Subject: METROWEST DCO EXAMINATION – ISSUE SPECIFIC HEARING 3 (ENVIRONMENTAL MATTERS) – ENVIRONMENT AGENCY WRITTEN RESPONSE TO AGENDA ITEM 5 (FLOOD RISK, DRAINAGE AND CONTAMINATED WATERS)

Our ref: WX/2019/133441/01-L09
Your ref: TRO40011
Date: 10 January 2021

**METROWEST DCO EXAMINATION – ISSUE SPECIFIC HEARING 3
(ENVIRONMENTAL MATTERS) – ENVIRONMENT AGENCY WRITTEN RESPONSE
TO AGENDA ITEM 5 (FLOOD RISK, DRAINAGE AND CONTAMINATED WATERS)**

# Level 1 Strategic Flood Risk Assessment

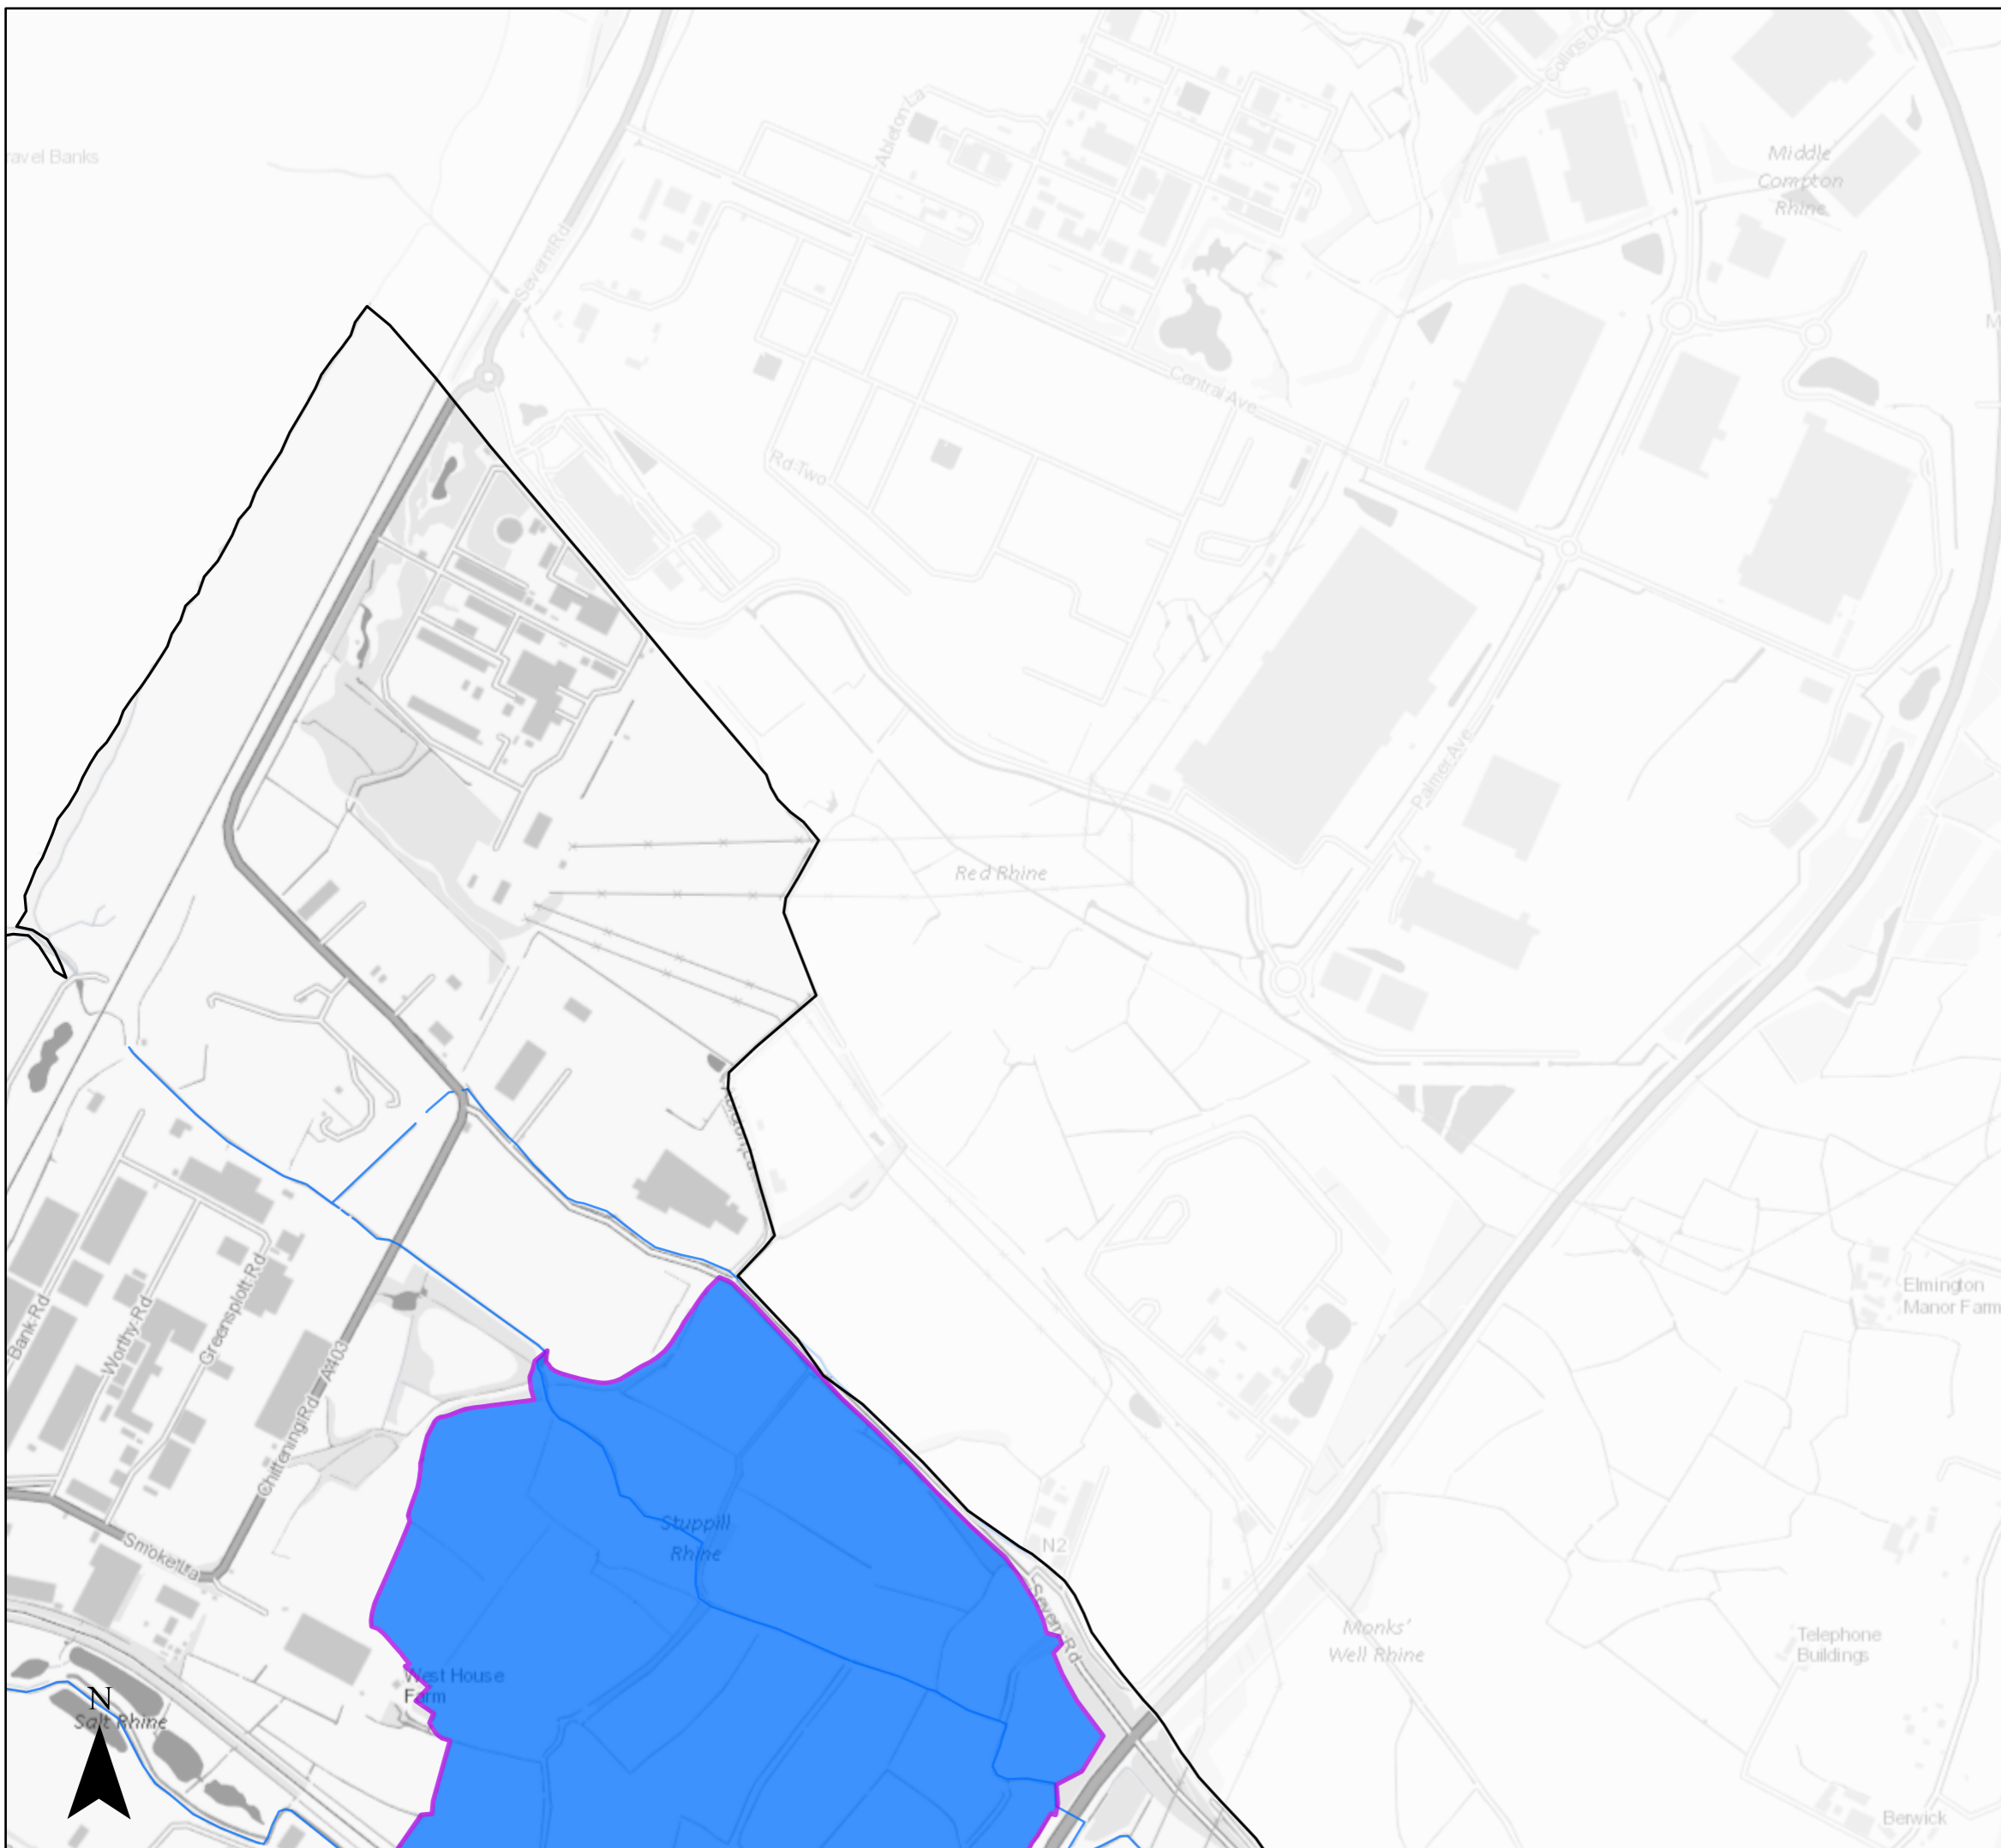
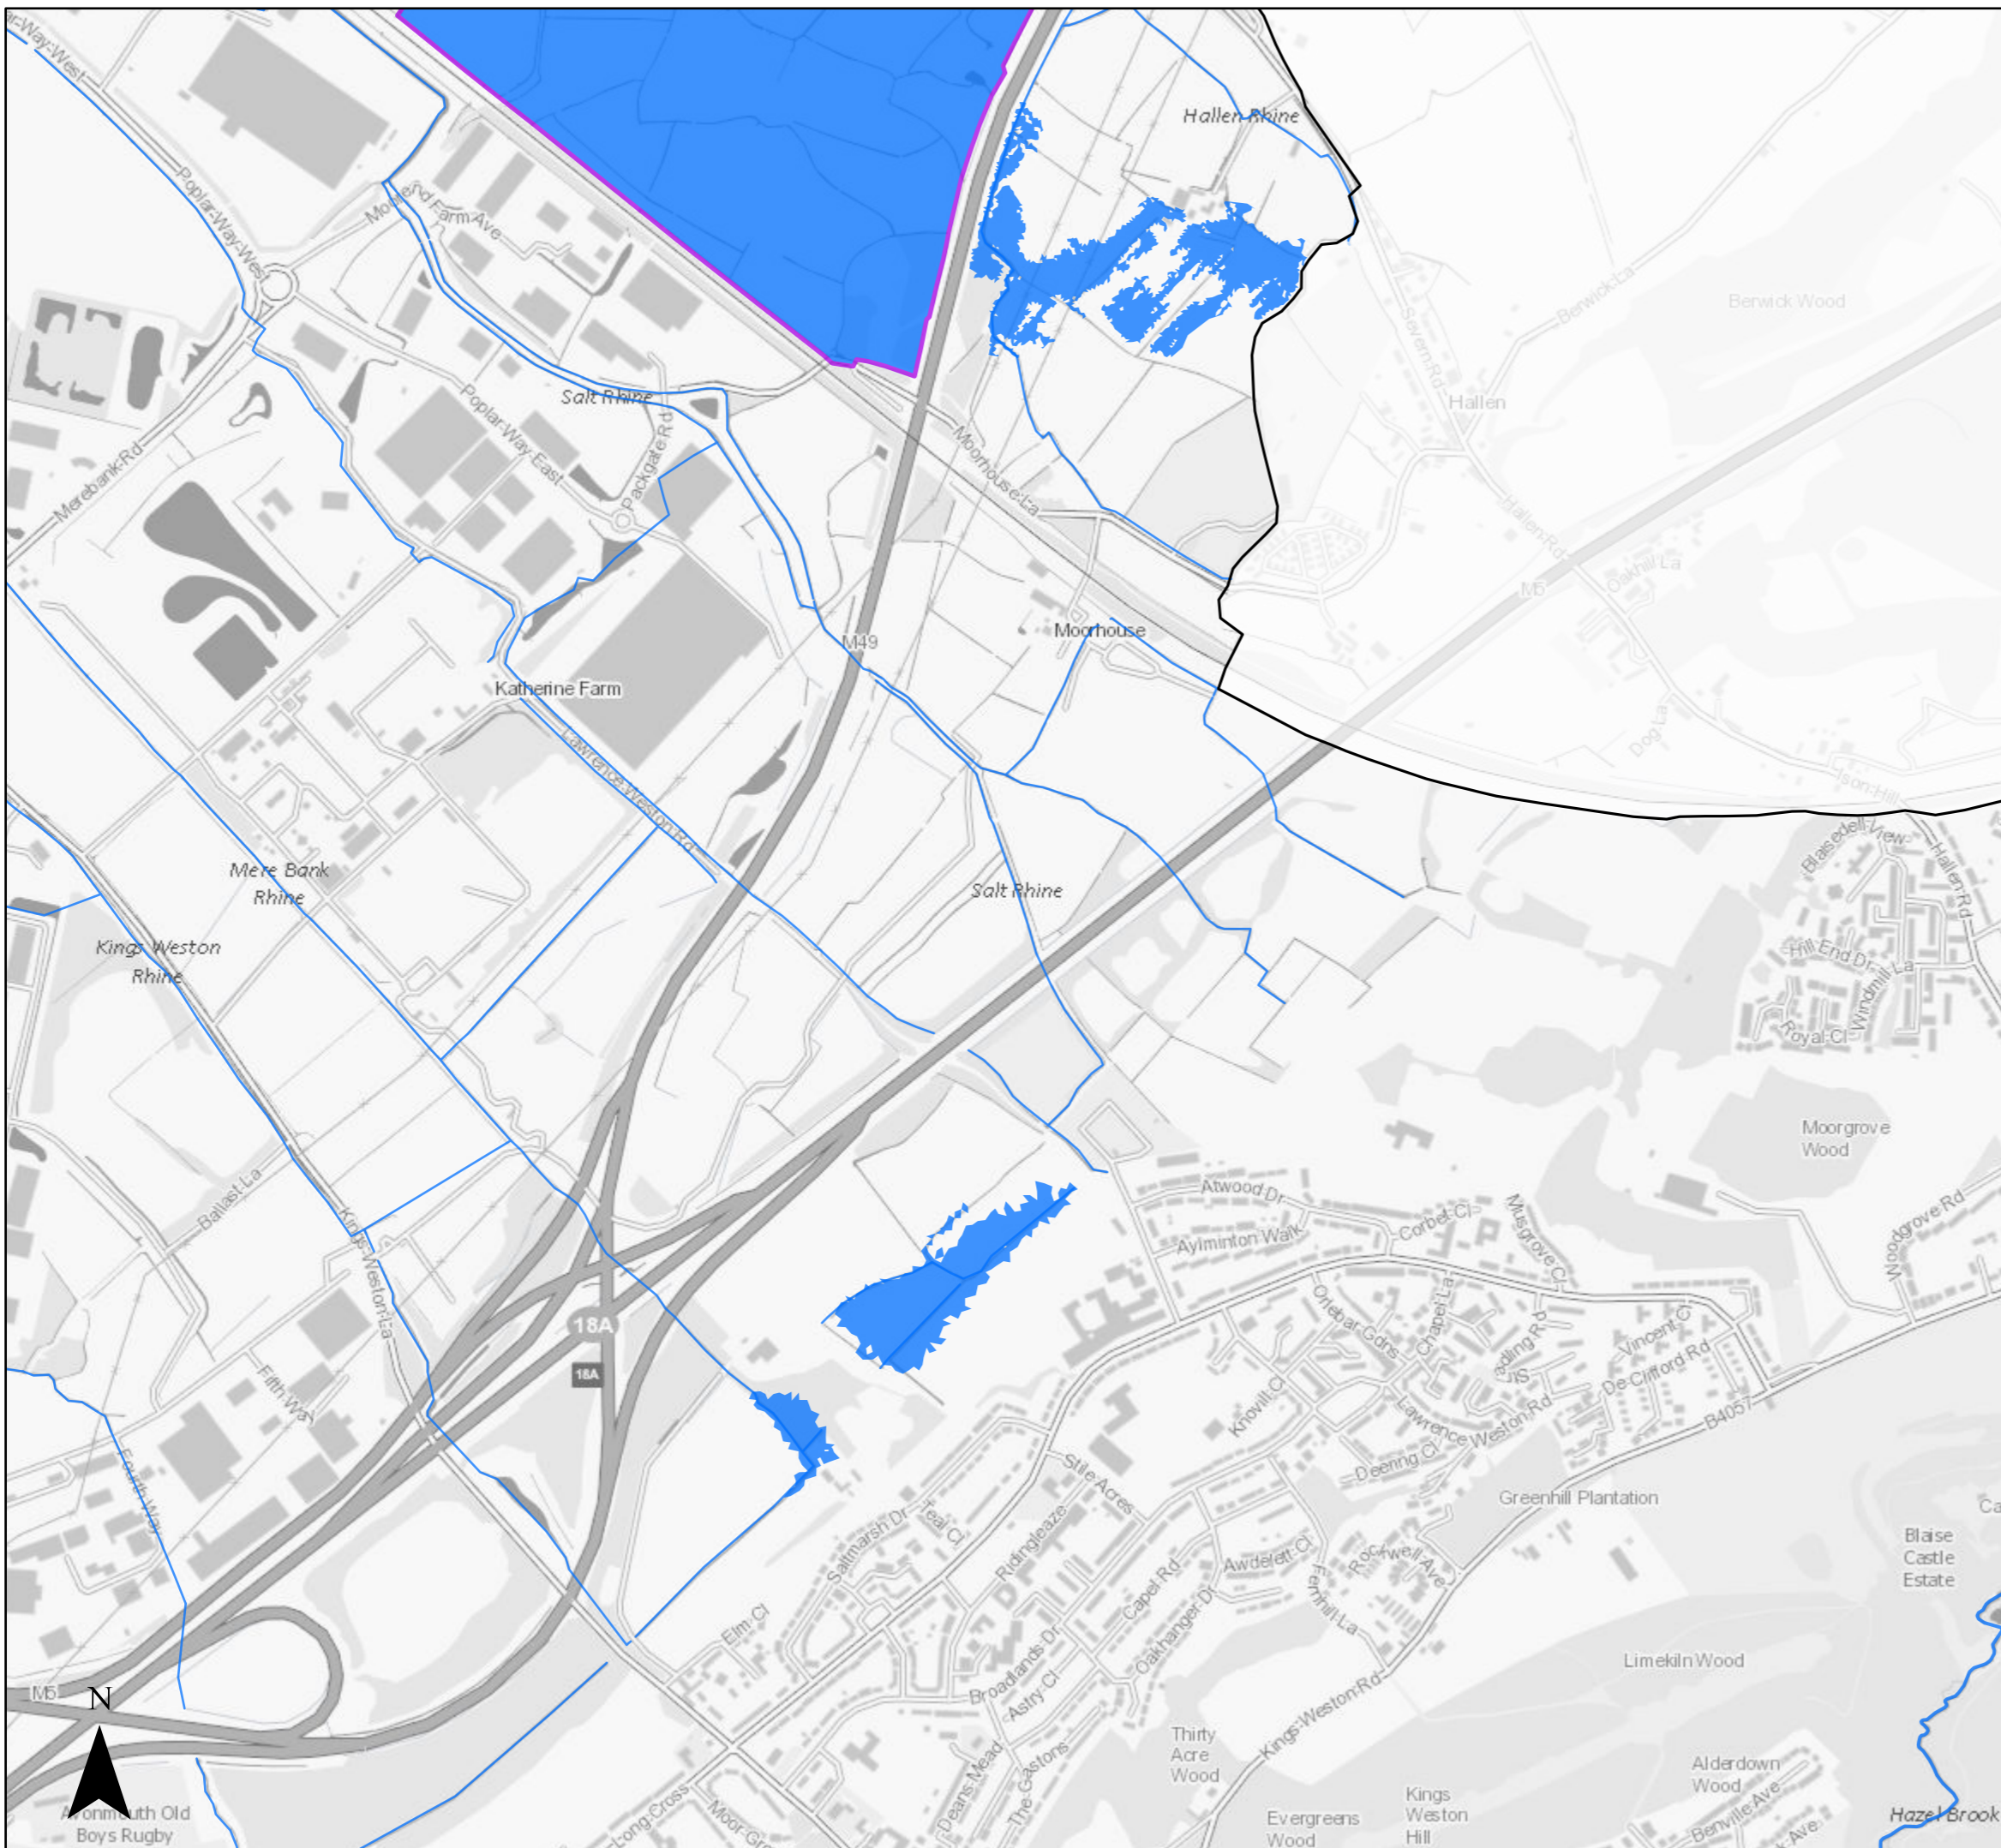
The applicant's representatives have recently cited the updated Bristol Strategic Flood Risk Assessment as evidence that no part of the application area is located within Flood Zone 3b (functional floodplain). This is obviously at variance with the applicant's own site specific flood risk model, which should be considered a more detailed assessment of the actual flood risk. Accordingly, the Agency must advise that parts of the application area are within Flood Zone 3b (functional floodplain), as detailed in the applicant's Flood Risk Assessment.
